# HAYES STRUCTURAL

**Date:** July 31, 2025

**Re:** 25-FRM-155  
Framing Deviation  
Lot 39 Tobacco Road  
108 Golden Leaf Farms Rd.  
Angier, NC 27501  
Permit No.: SFD2505-0049

At your request, the plans and provided information were reviewed for the above referenced single family residence under construction to address framing deviations between the approved plans and roof truss layout.

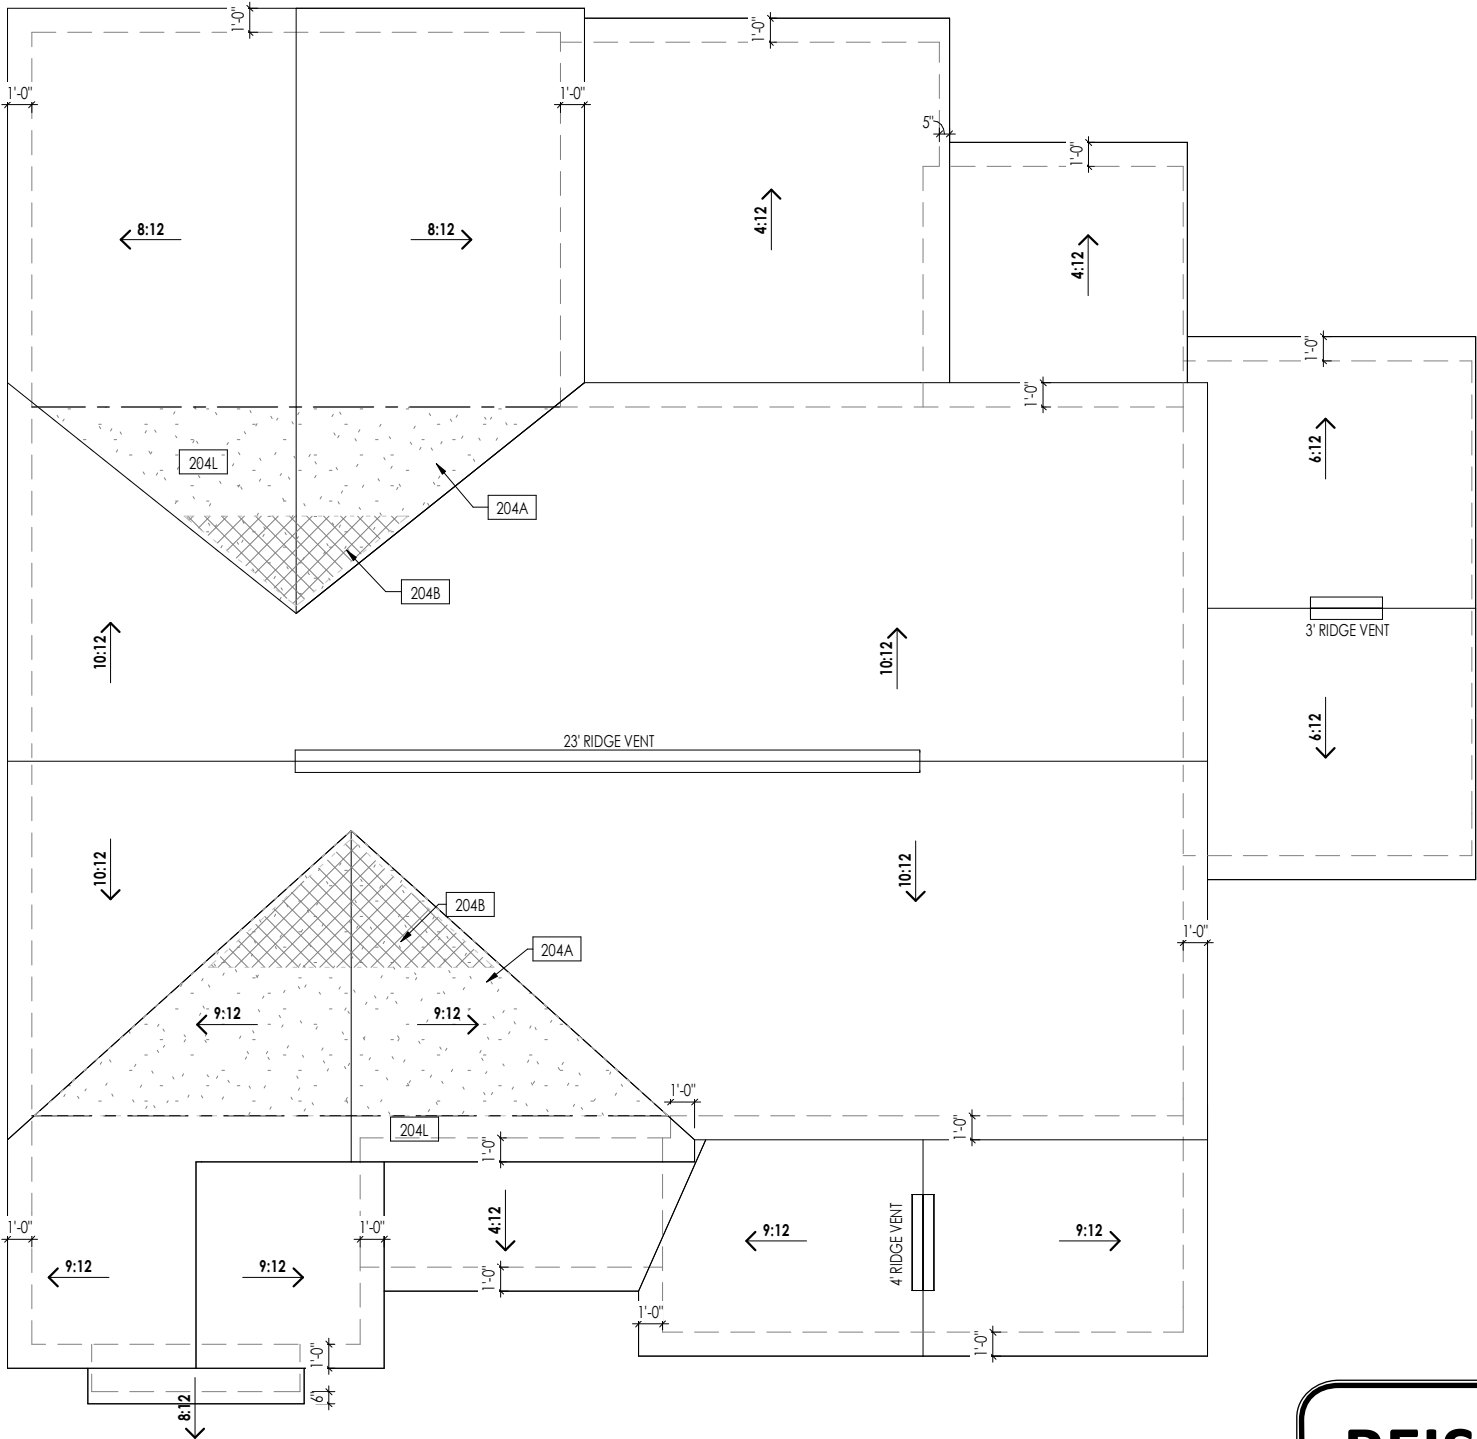
The "end joist" specified above the rear porch in the approved plans was omitted. The roof above the rear porch is constructed with engineered roof trusses.

The "as-built" roof framing installed per the roof truss layout is adequate. The plan specified "end joist" is not required.
